Subject: **Hong/Kao Residence Remodel/Addition and new Detached Accessory Dwelling Unit
5425 W Mercer Way
Permit No. 2306-124**
Quantum Project #23127.01

We have received the correction notice on the above-referenced project dated 12/23/2023. Below are our responses to the structural comments. All changes to the drawings due to a plan check comment have been clouded on the drawings.

ROOF PLAN
1/4" = 1'-0"

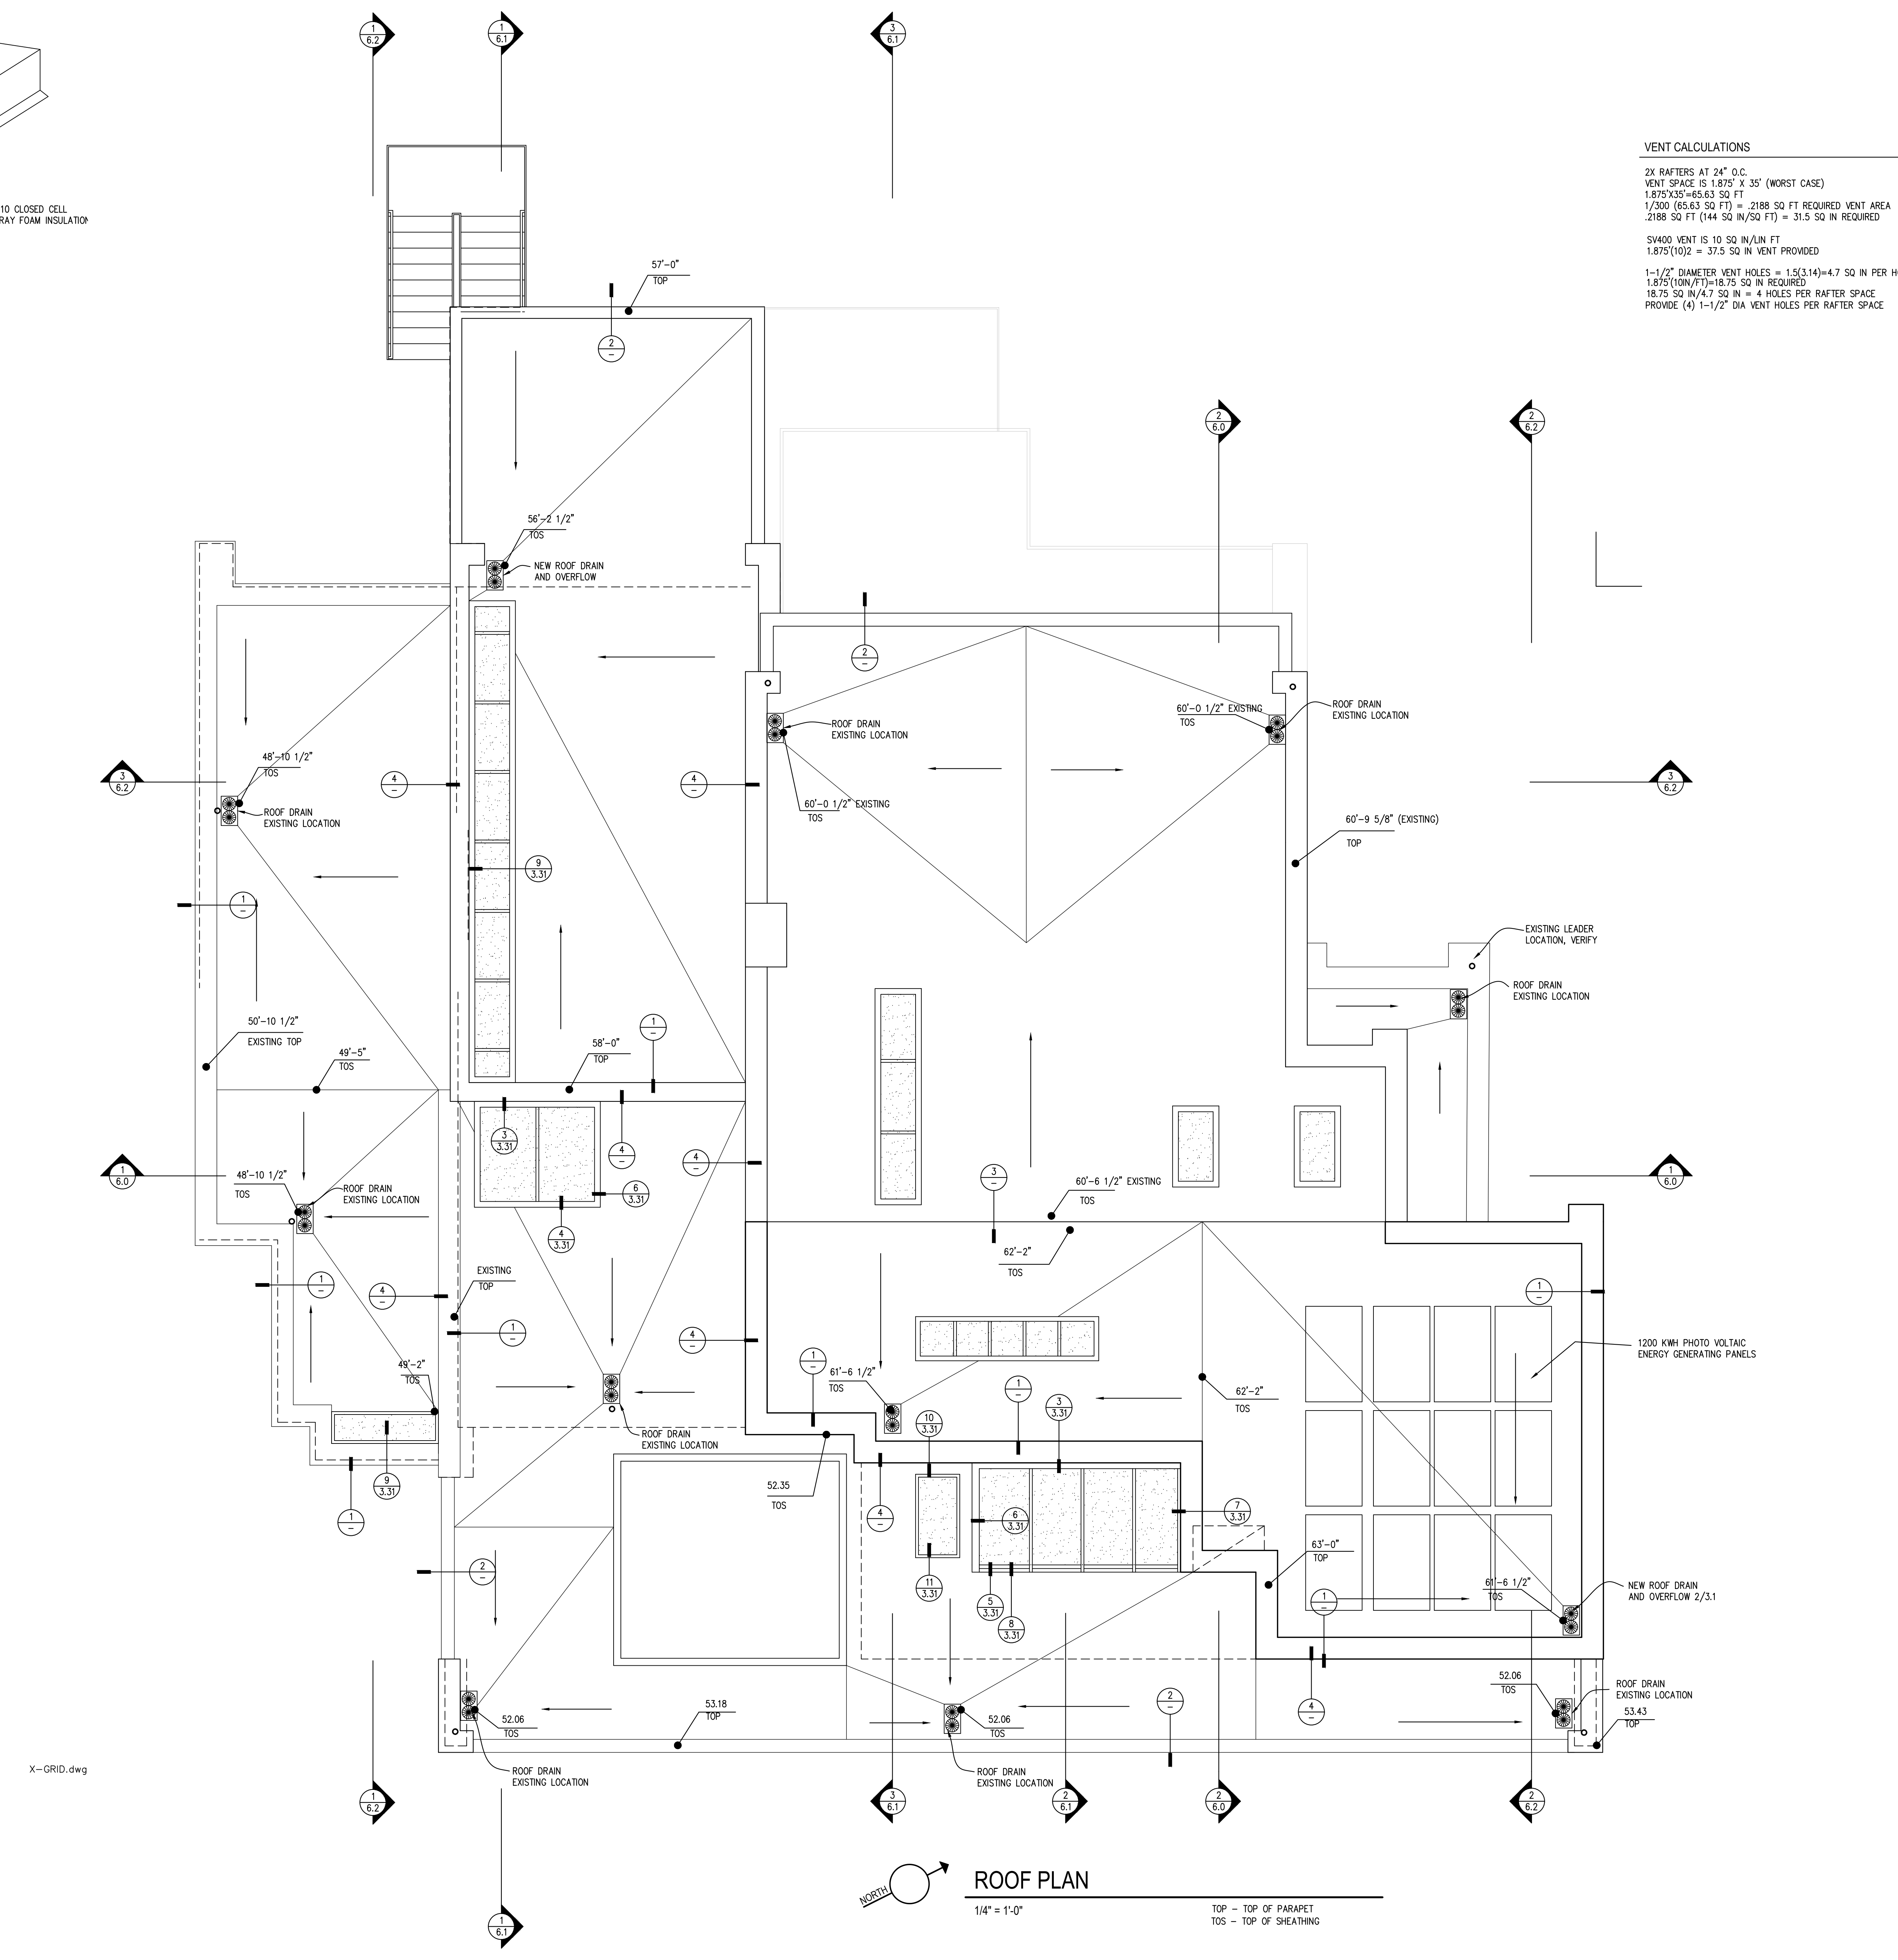
1. Page 5 of 225 of the original calculations identifies the east low roof of the main house with 2" of gravel and a dead load of 33 psf. The Roof Plan, Sheet 3.3, now shows the location of this gravel roof. Please verify that new and existing framing members can support this dead load. See framing on page 62 of 138 of the new calculations that shows the framing (UJ1, P1, UB1, and existing members).

The 2" gravel roof area has been revised to only include the area over the garage. Please see revised roof plans and attached structural calculations for members UJ1, UB1, UB3, and P1.

FOUNDATION PLAN
 1/4" = 1'-0" (E) - EXISTING

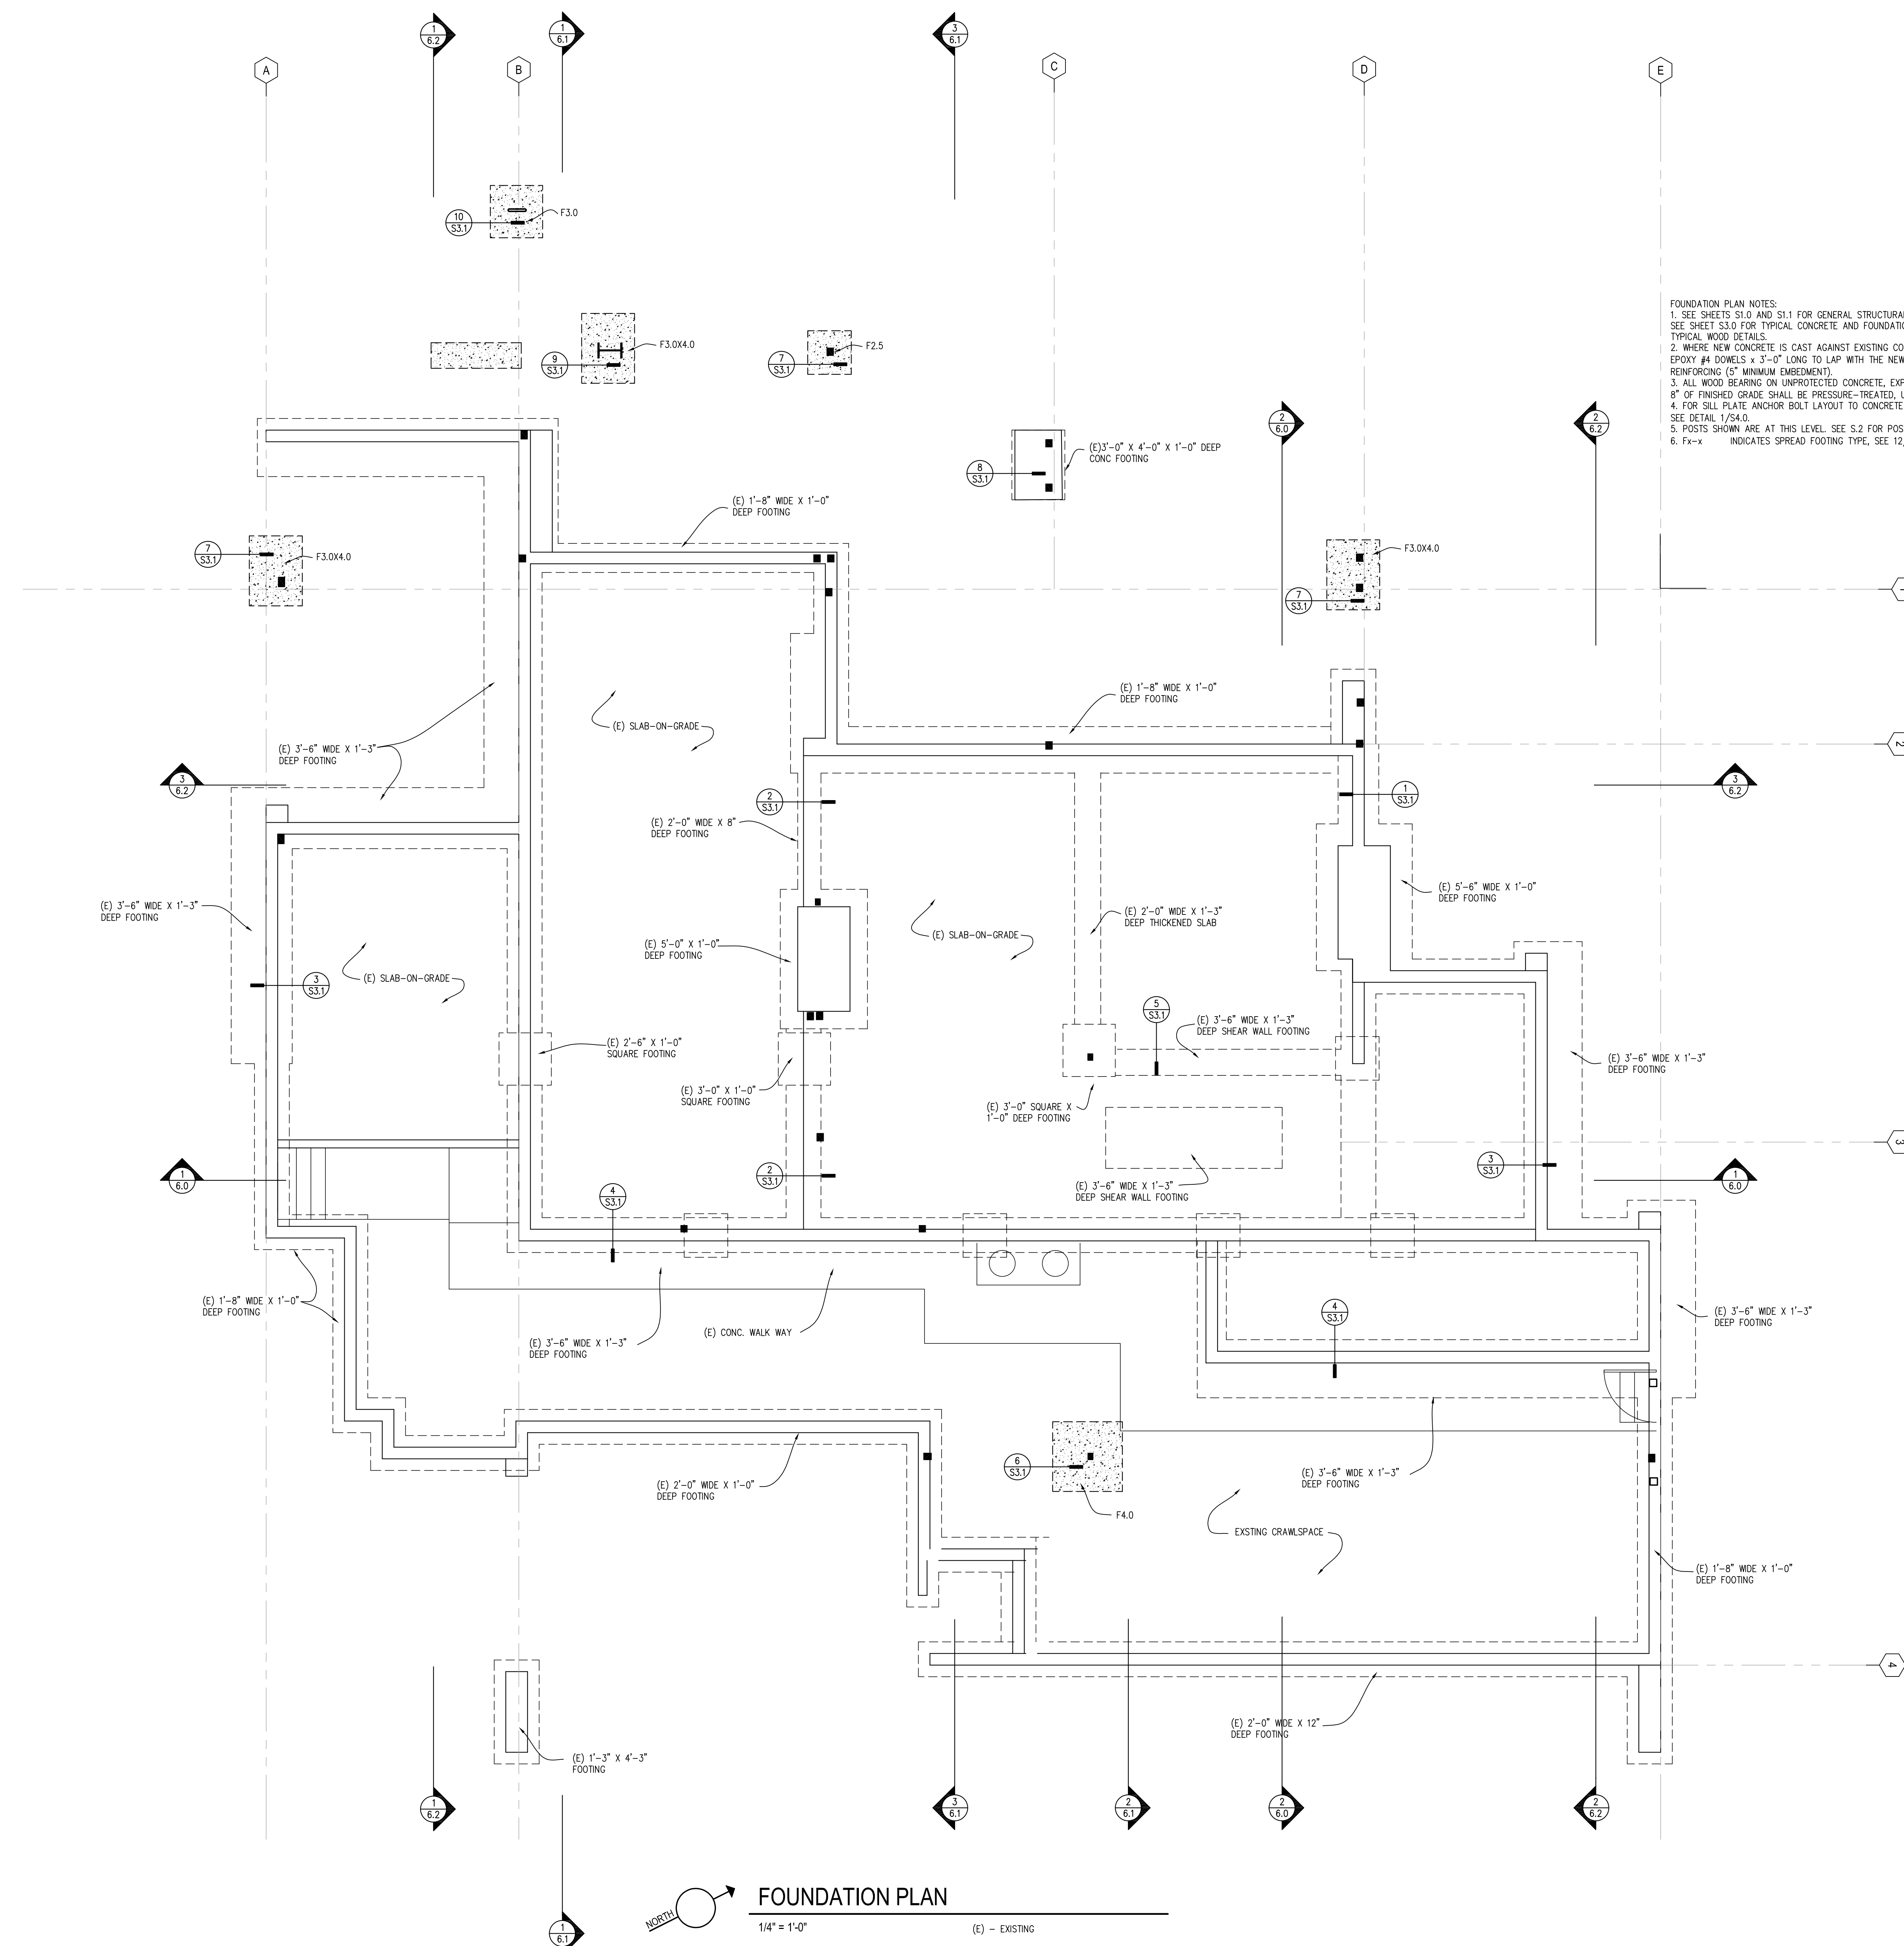
2. Page 46 of 138 of the new calculations shows the new design of B7 at the main house with the reaction load at the existing footing. Page 4 of the new calculations shows the existing footing as F3 which is a 3' x 4' x 1' footing. Page 17 of the new calculations appears to assume this is an existing 4' x 4' x 1' footing. Please verify your design.

In order to provide adequate bearing capacity, the existing 3' x 4' x 1' footing at F3 has been modified to a 4' x 4' x 1' square footing. Please see sheet S.1 and detail 8/S3.1 for footing dimensions and reinforcing.

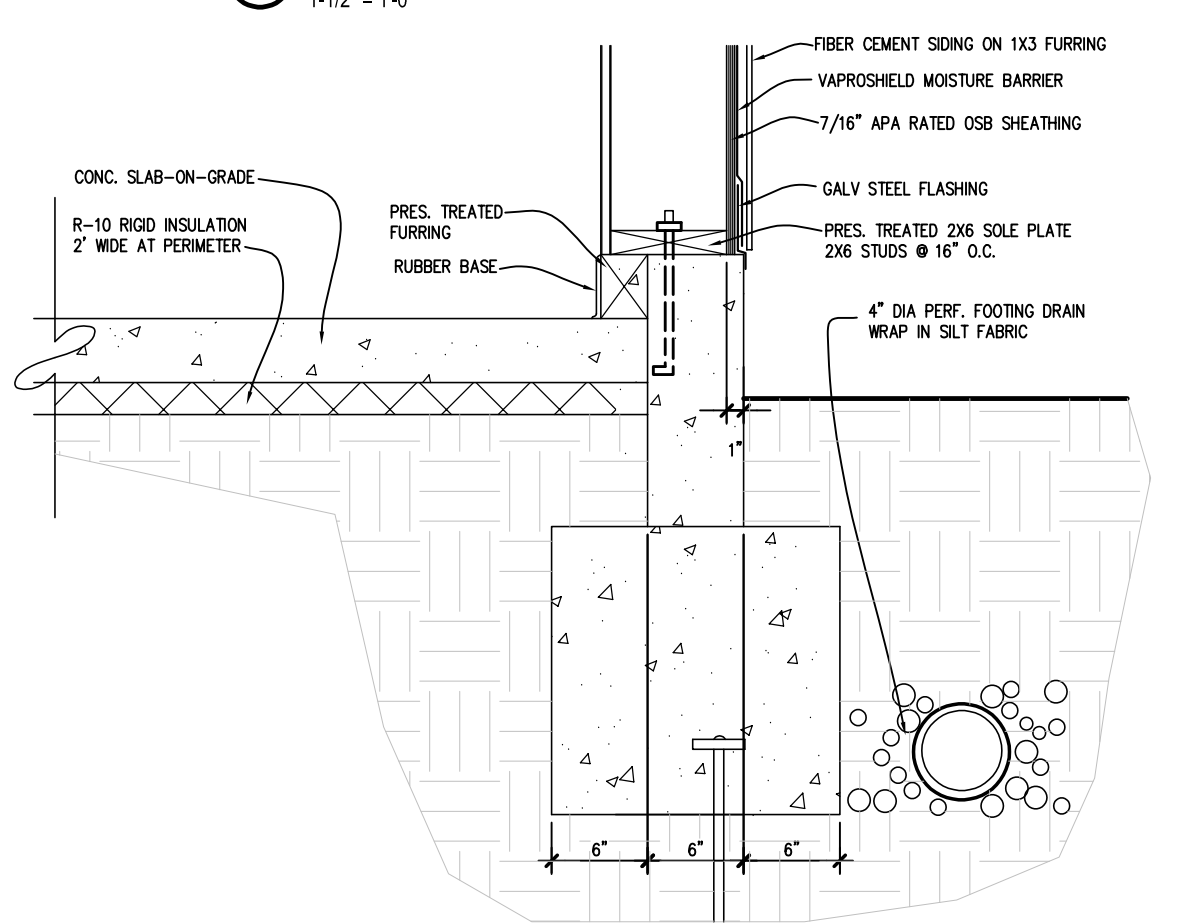
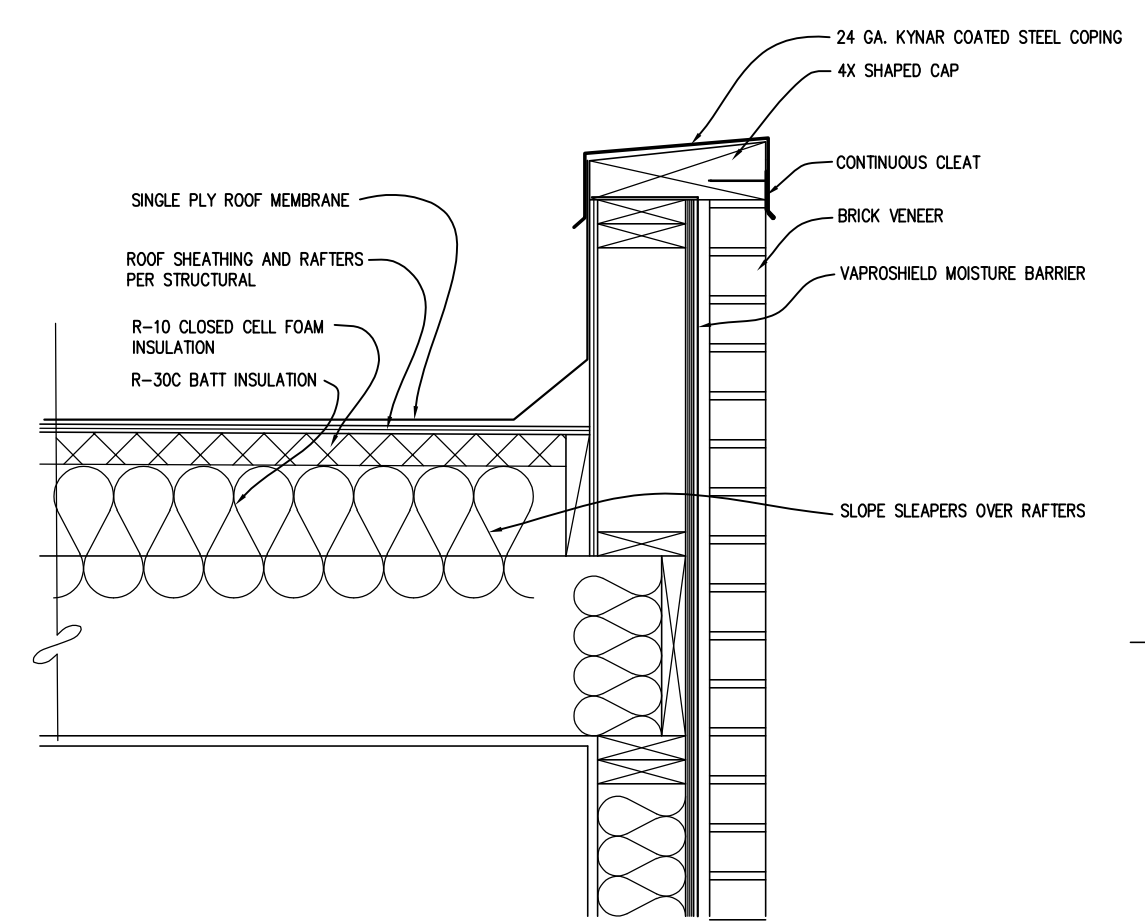
10. At the heated area on the lower floor, the exterior wall must have continuous insulation. The details are not showing the concrete stem wall insulated; for example, see Details 4 & 5/3.0.

Structural details have been revised to show exterior insulation. Please see sheet S3.0.
